Our Ref: TR010026

Date: 27 September 2018

### **Application by Highways England for an Order Granting Development Consent for the A30 Chiverton to Carland Cross Scheme**

#### **Advice following issue of decision to accept the application for Examination**

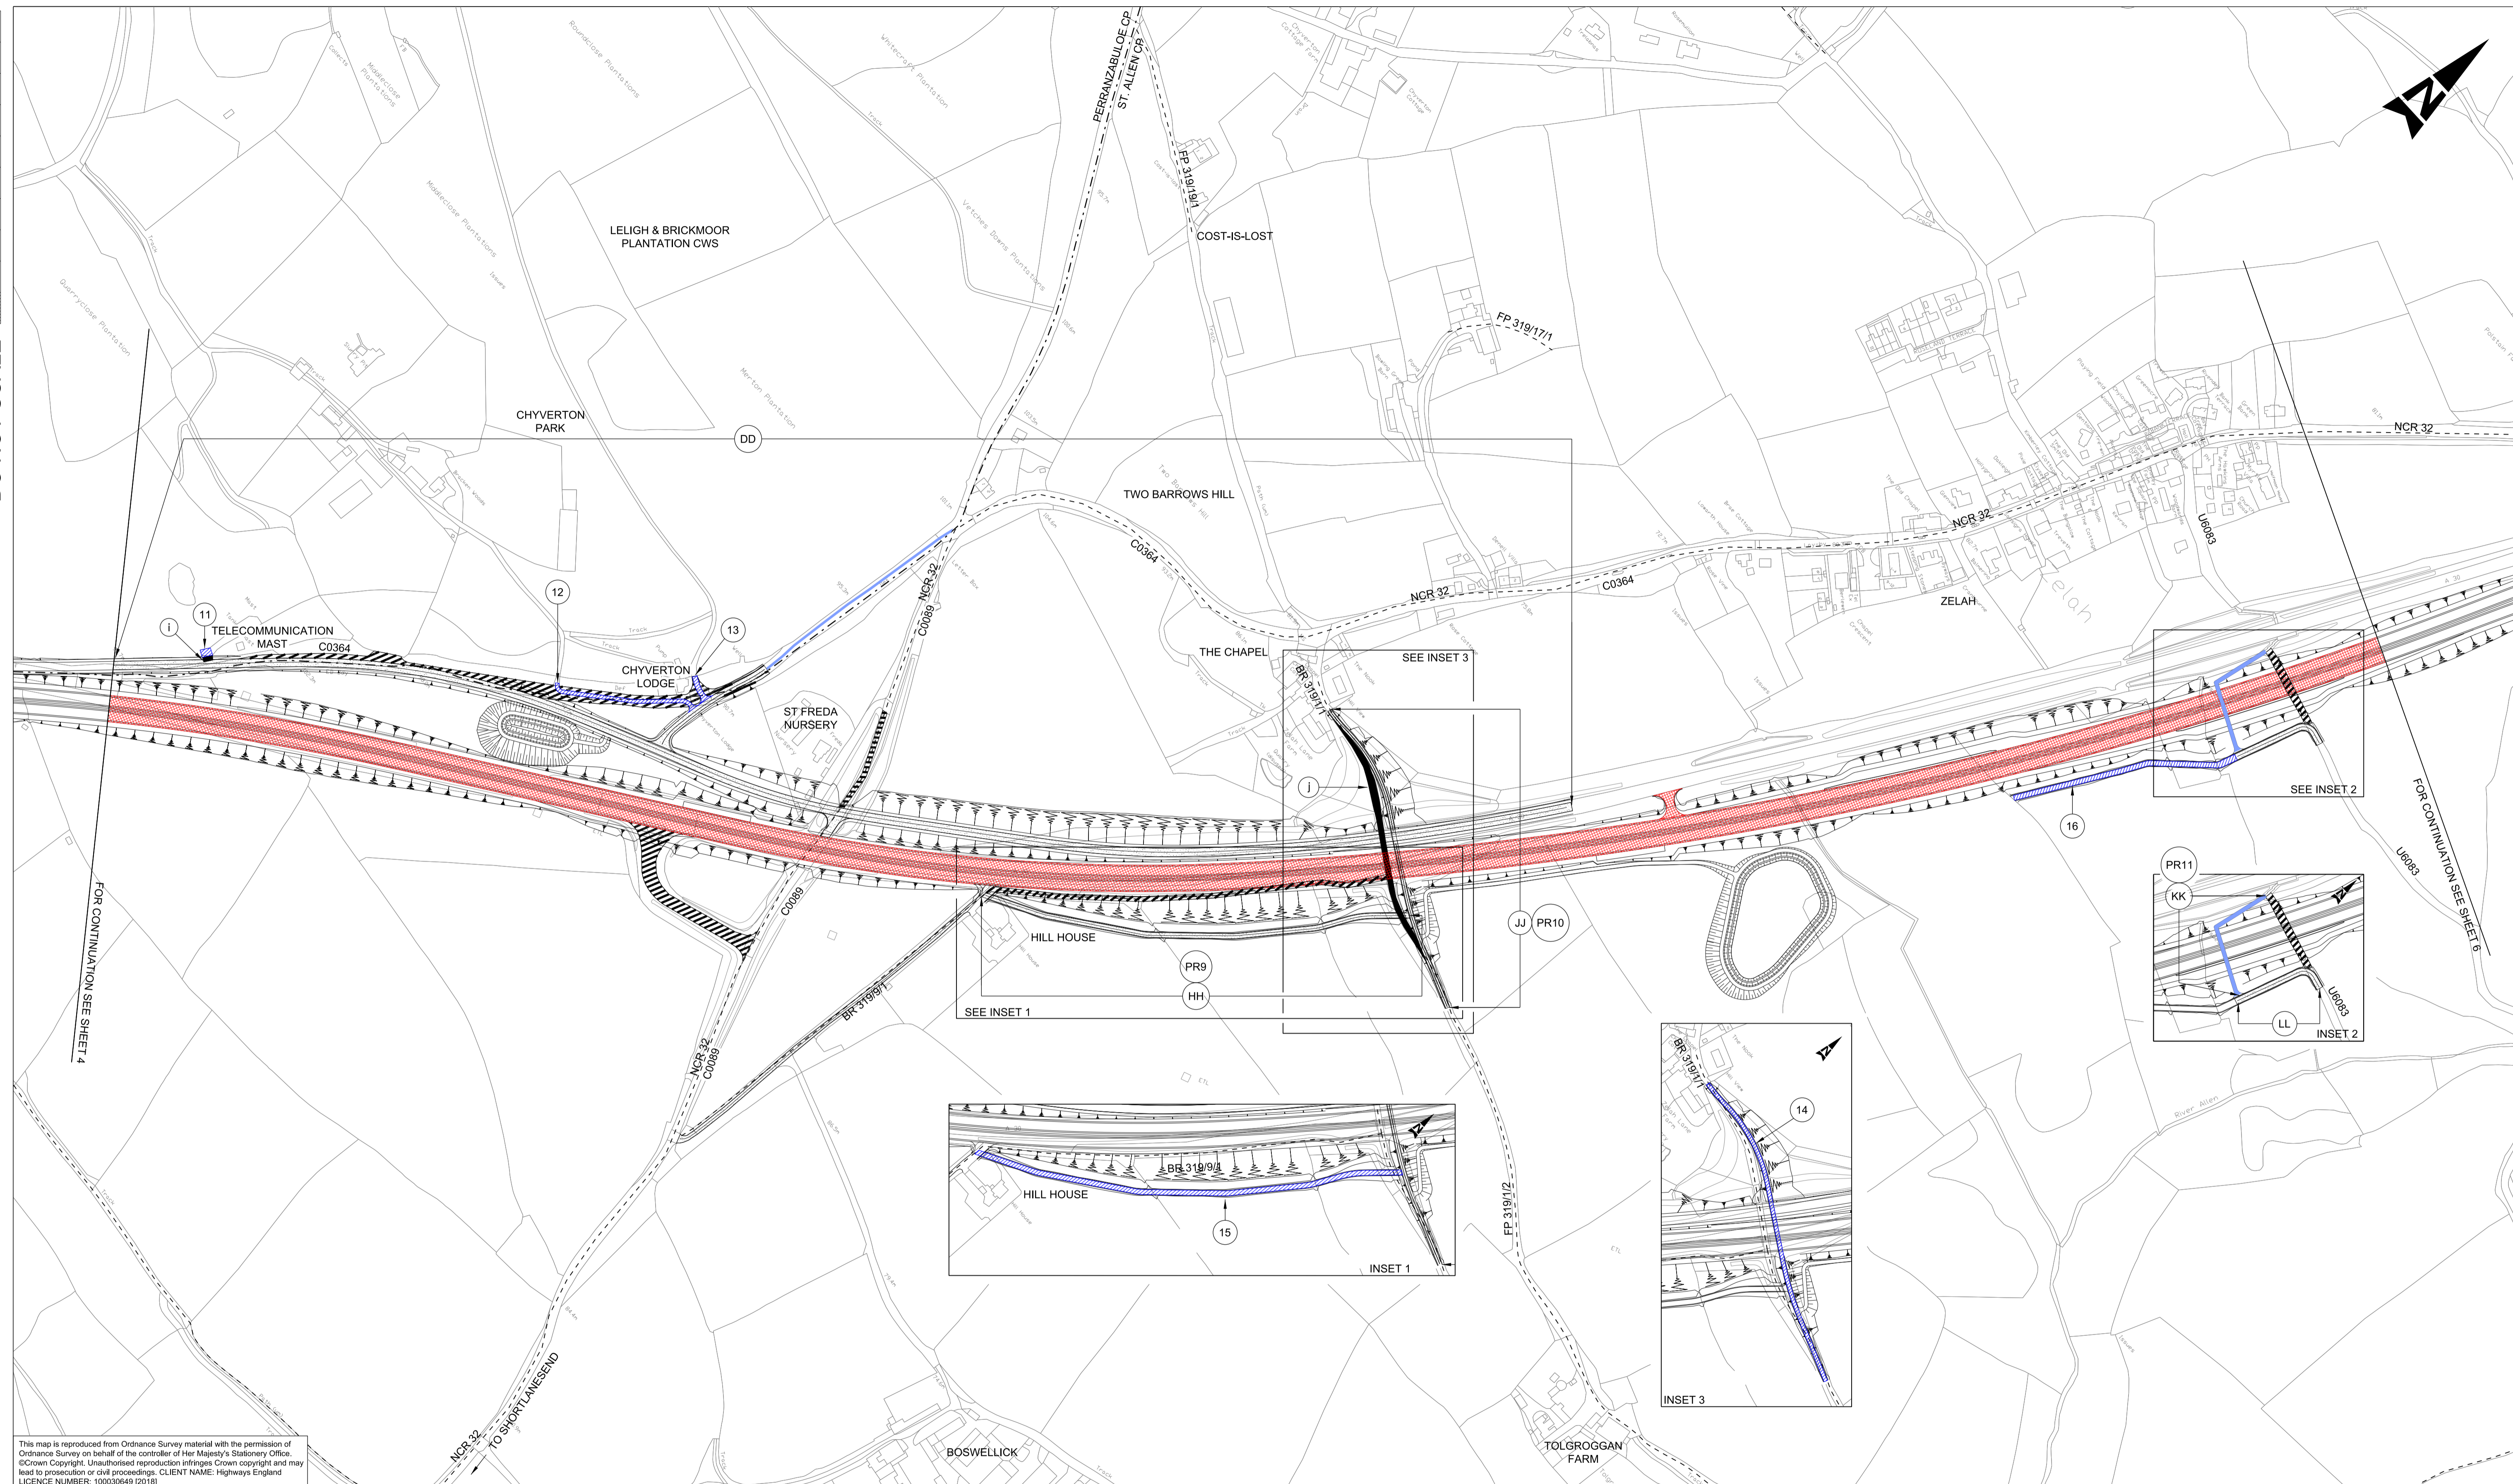
A minor discrepancy has been noted in the Checklist (Box 30: Regulation 5(2)(i)). The Applicant is advised to carry out a full review of the cross-references between the plans and the draft Development Consent Order to ensure that all information is recorded accurately.

Drawing Title: **WORKS PLANS APFP REGULATION 5(2)(J) SHEET 5 OF 8**

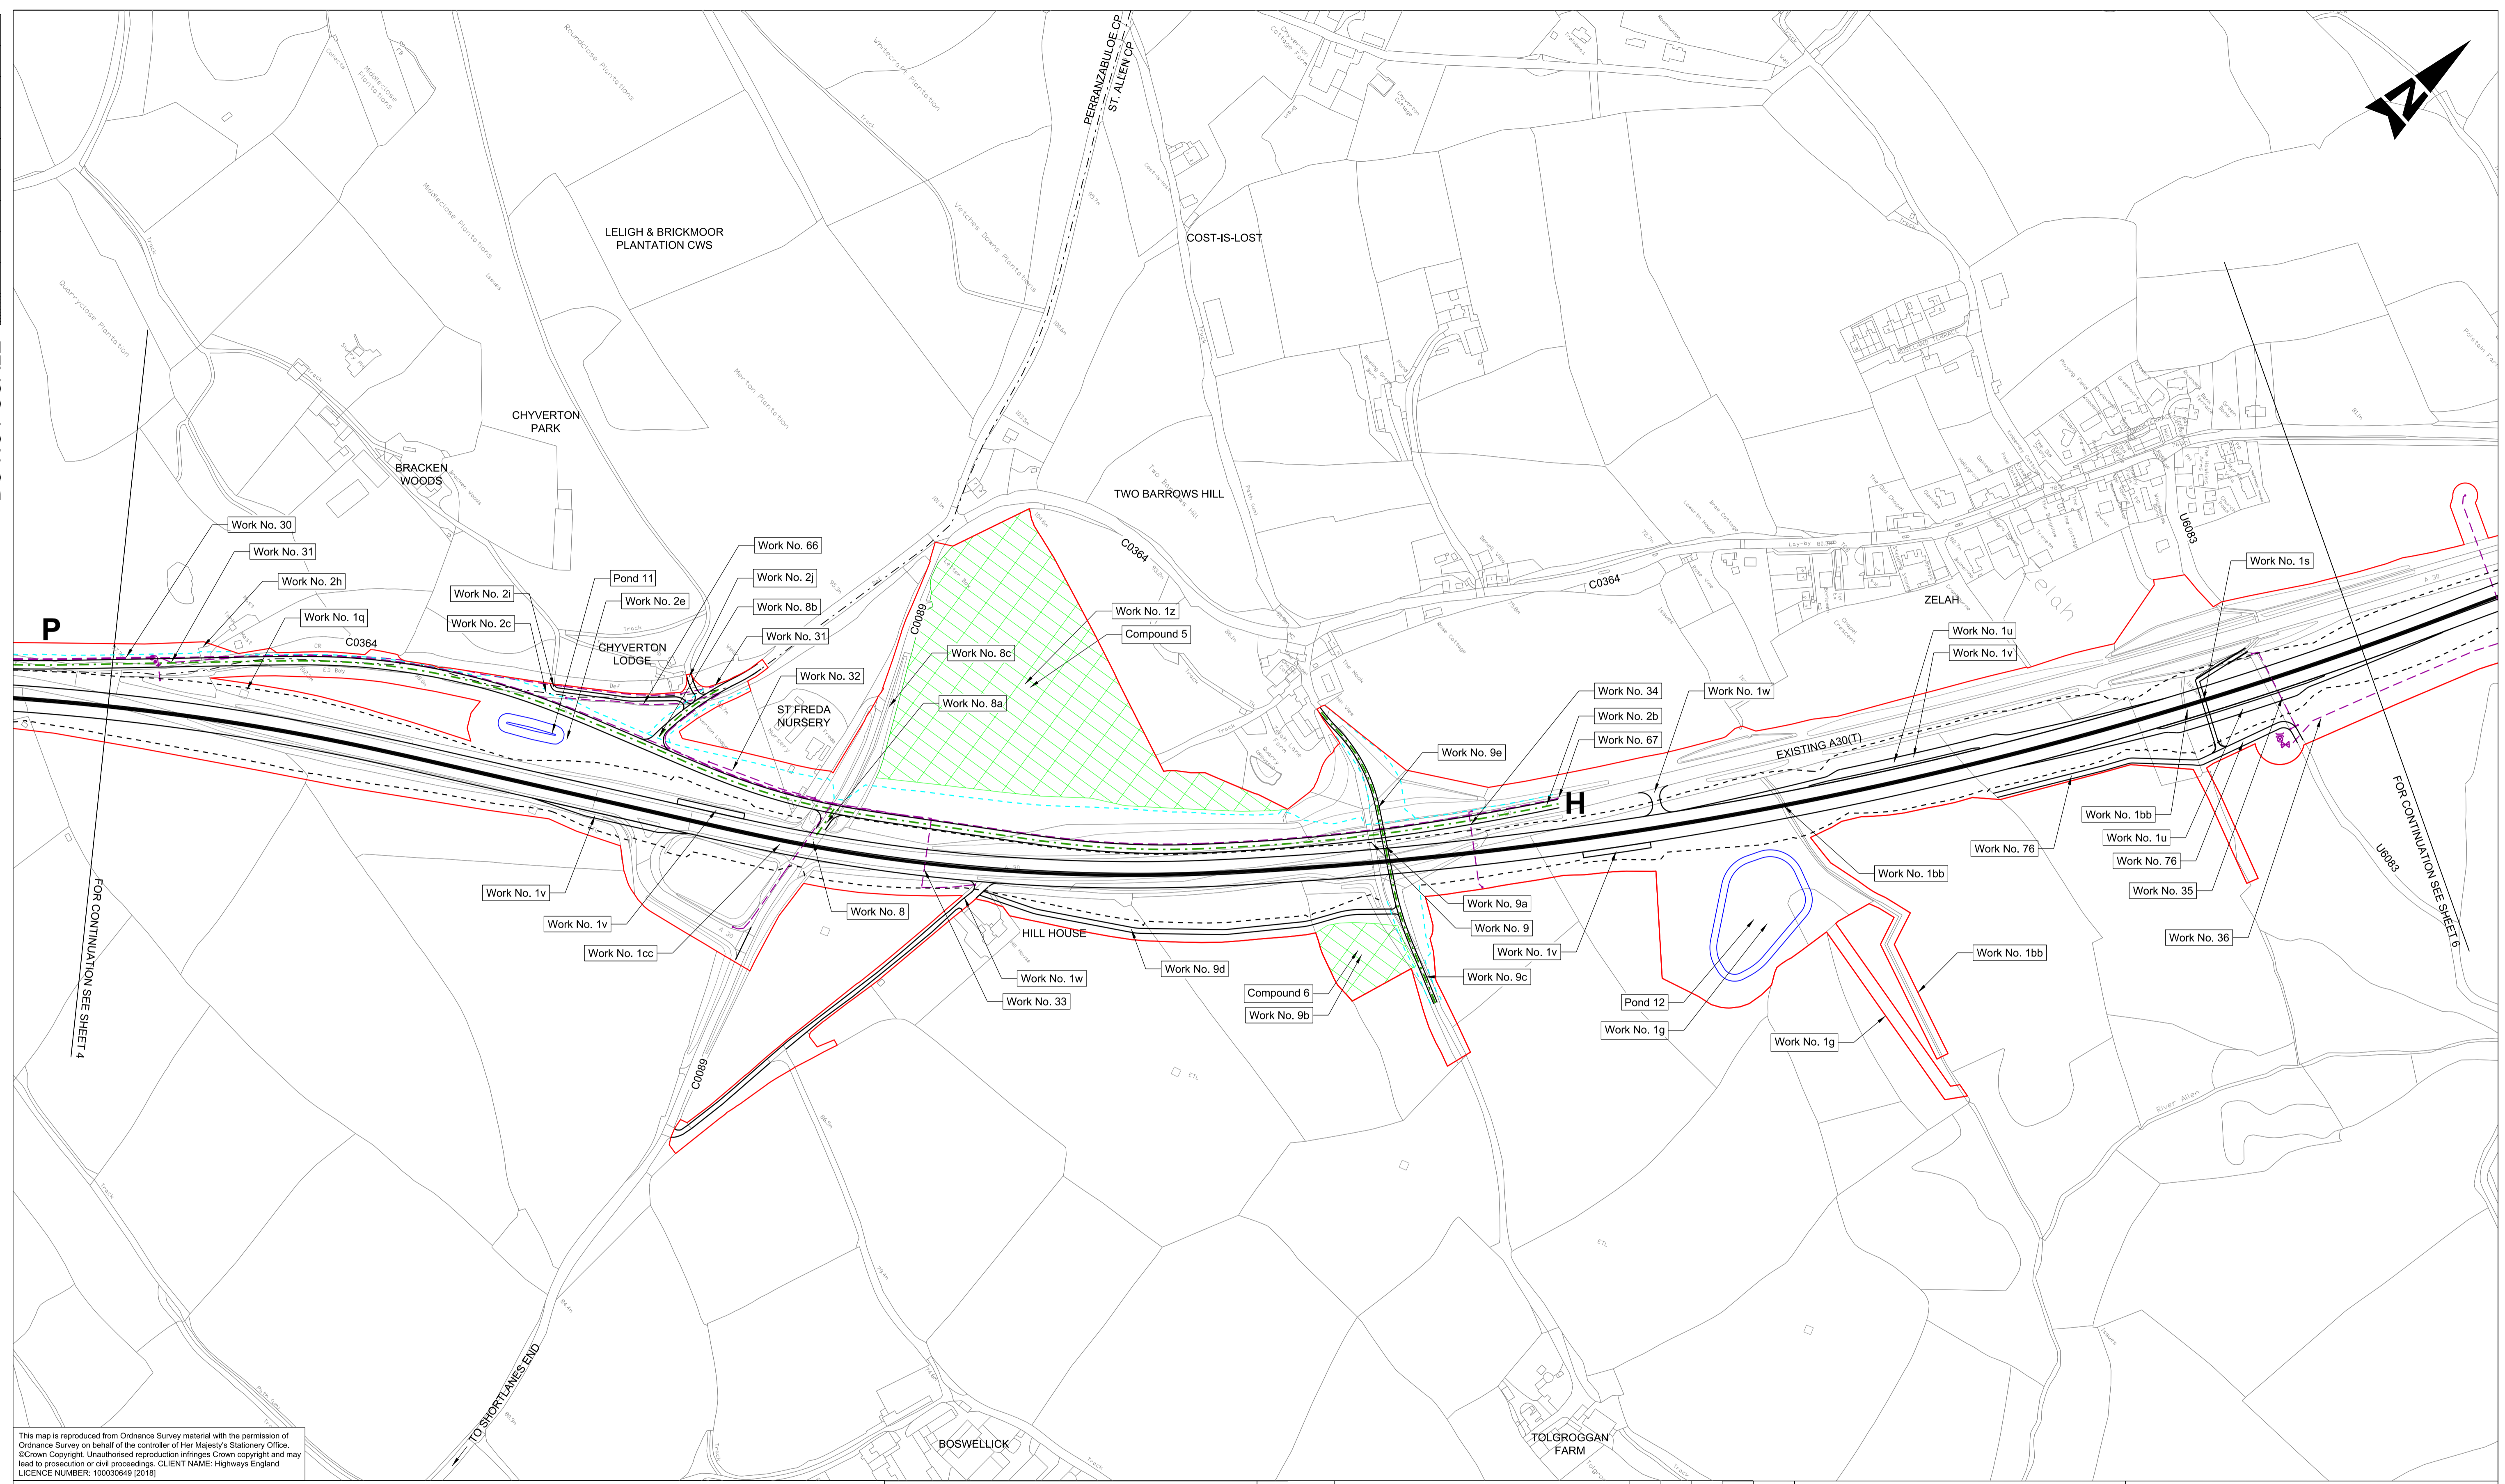
With regard to inset C on sheet 5 the Applicant is advised to provide a Land Plan and Works Plan that clearly identifies the location of plot 5/11b in relation to the rest of the scheme and the works for which it is required.

A number of discrepancies have been noted in the Checklist (Box 30: Regulation 5(2)(i)). The application has been accepted on the basis of the Land and Works plans submitted for development within the Development Consent Order boundary. The appointed Examining Authority is likely to require an explanation regarding works that appear to extend beyond the boundary. The Applicant is advised to check the works plans to ensure that there are no errors and that all works are clearly identified.
